March 9, 2018

RE: Hotel Albuquerque NW Parking Lot
2000 Bellamah Ave NW
Grading Plan
Engineer's Stamp Date: 3/7/18
Hydrology File: J13D066

Based on the information provided in your submittal received on 3/7/18, this plan cannot be approved for Grading or Paving Permit until the following are corrected:

Drawing file: FINAL / J13D066 AA GP PAVE APPR.pdf

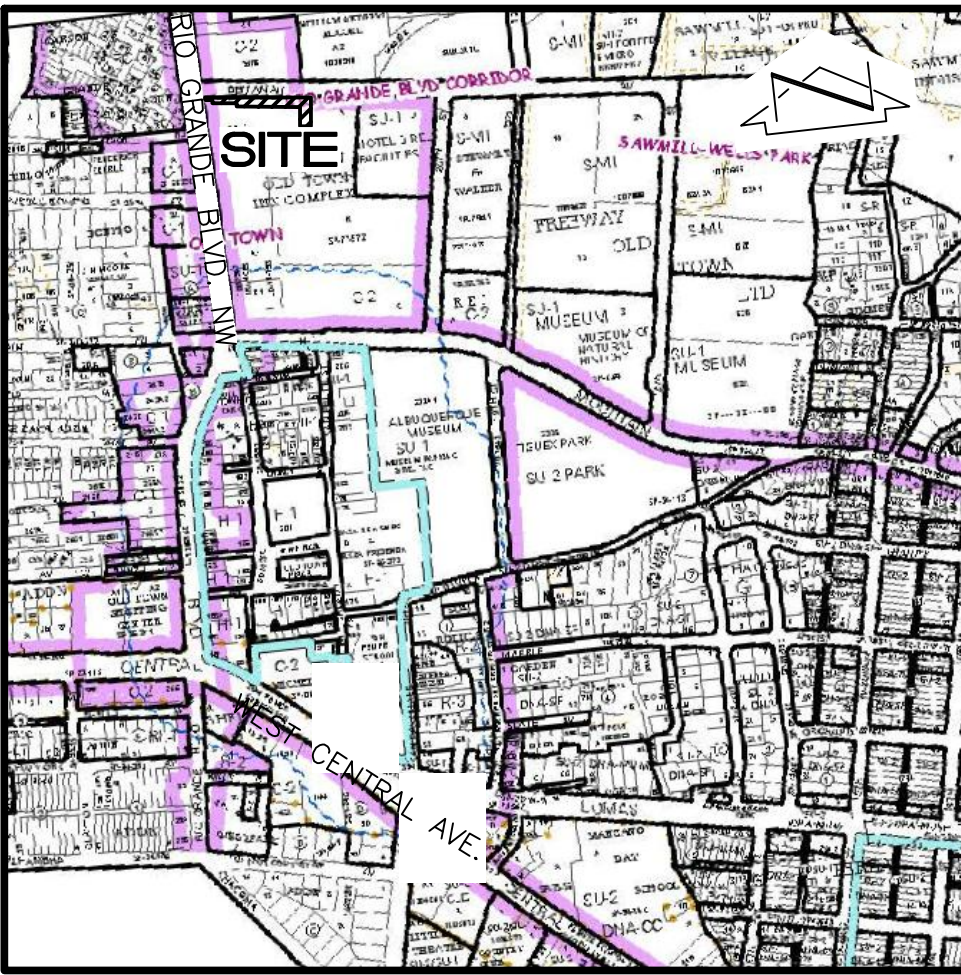
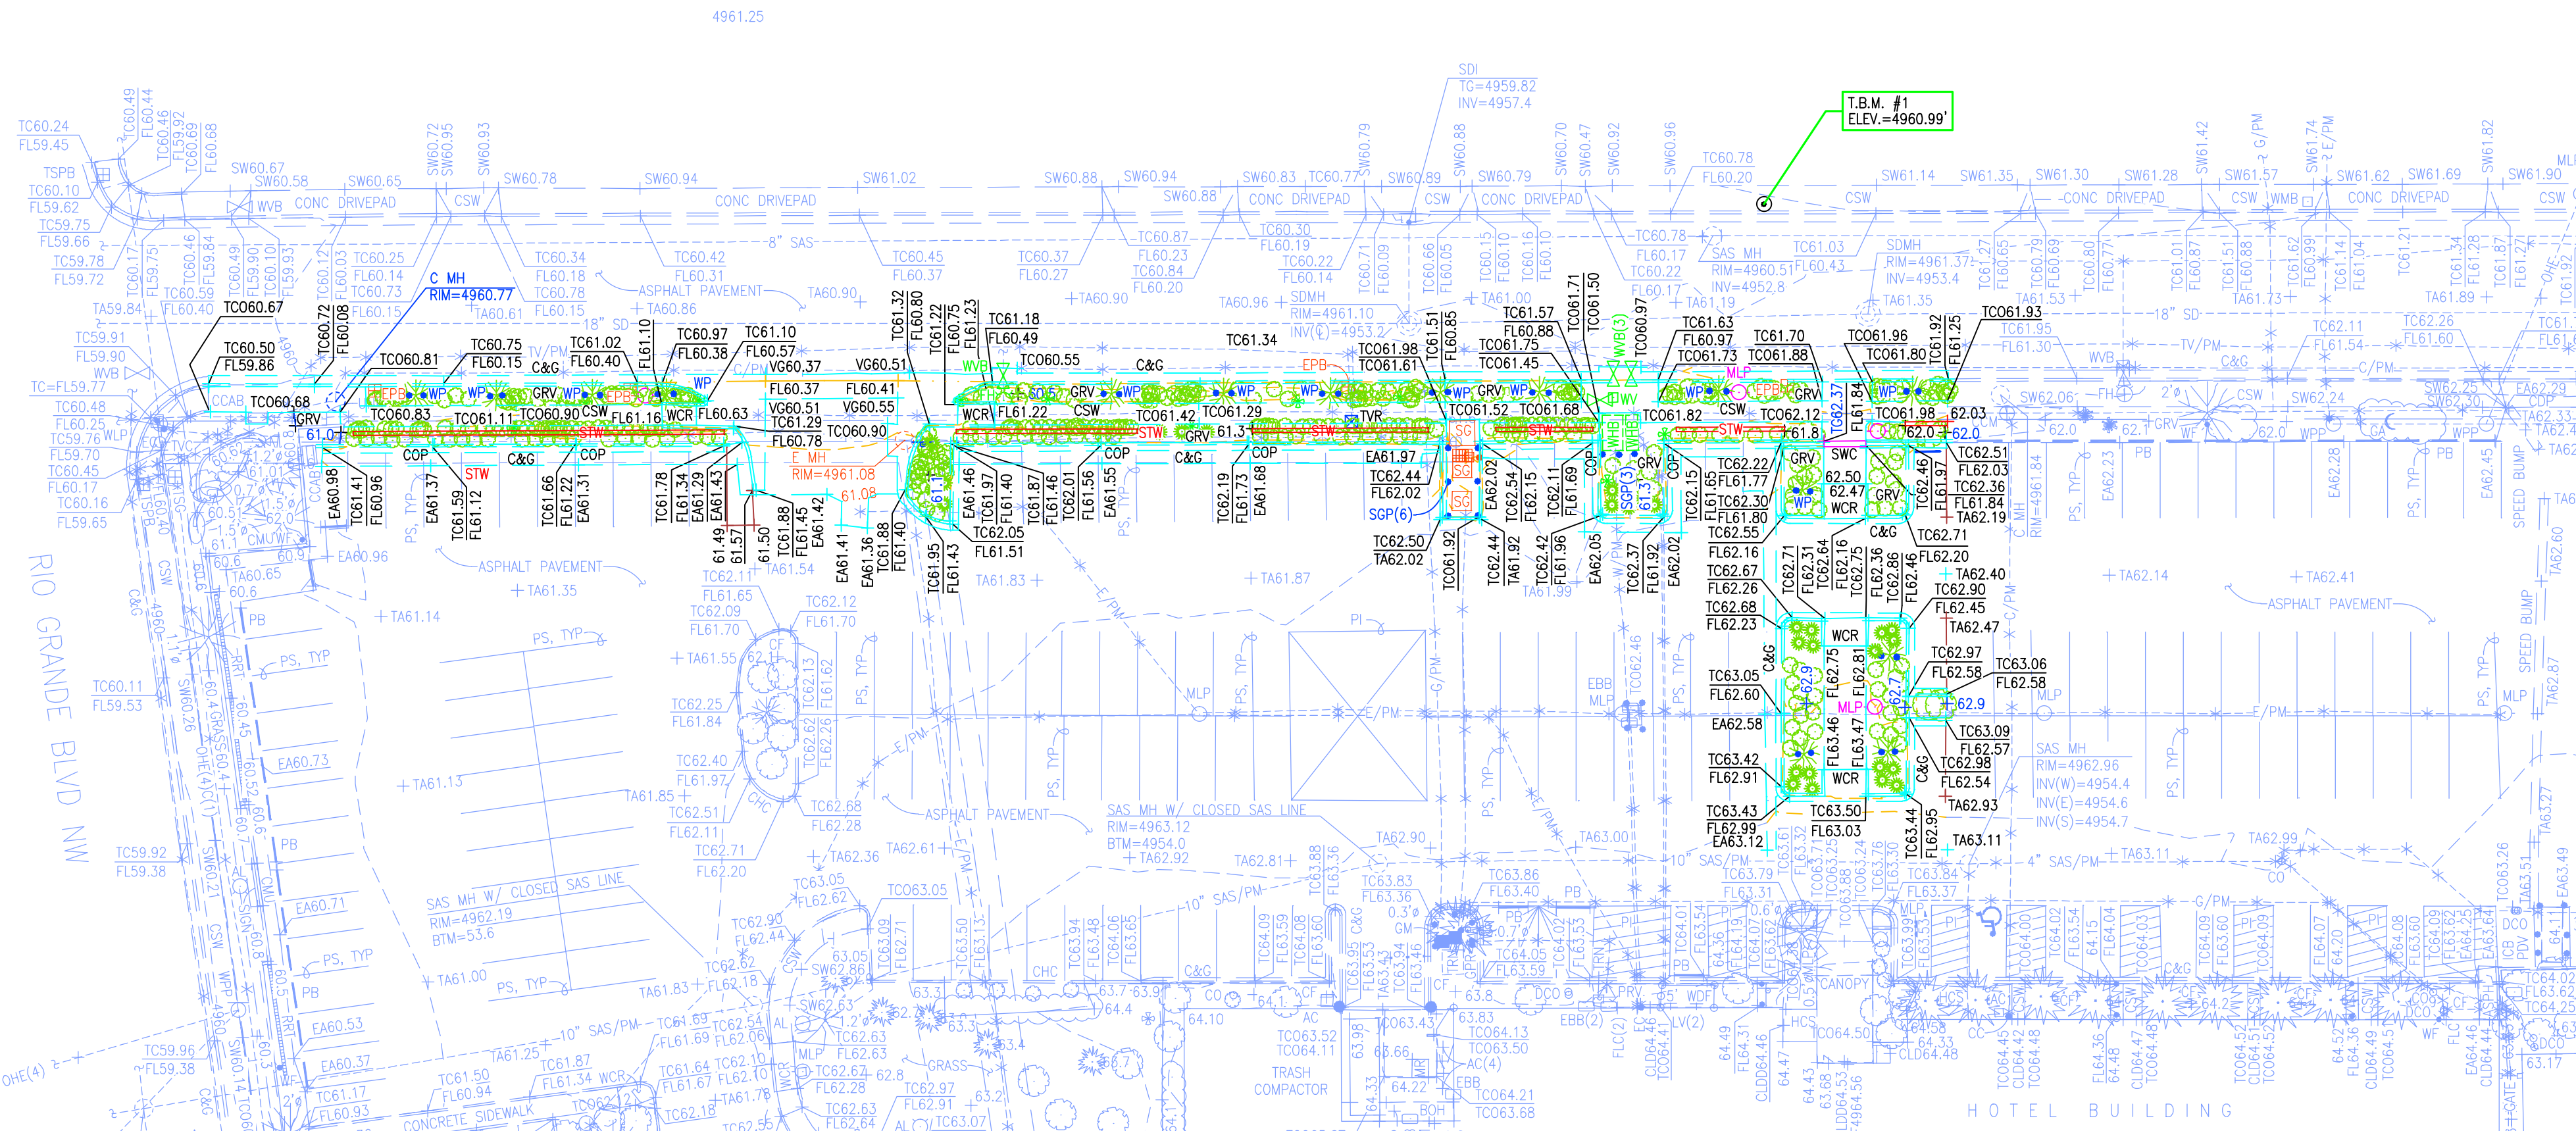
1. Each pond needs to be sized for the impervious area draining to it. Many of the ponds are undersized for the impervious area draining to them and one pond is oversized, but receives very little runoff (Area1 Pond). Can more runoff be directed into the Area1 Pond to meet the requirement?

2. Please recheck the first flush requirement calculation. For redevelopment, it should be calculated as $\text{Volume} = 0.26''/12 \times 44,302\text{SF}$.

3. Quantify the volume of first flush runoff that bypasses the first flush ponds and state on plans.
4. If the first flush runoff cannot be retained onsite, payment of fee-in-lieu will be required for the bypass amount at a rate of \$8/CF.
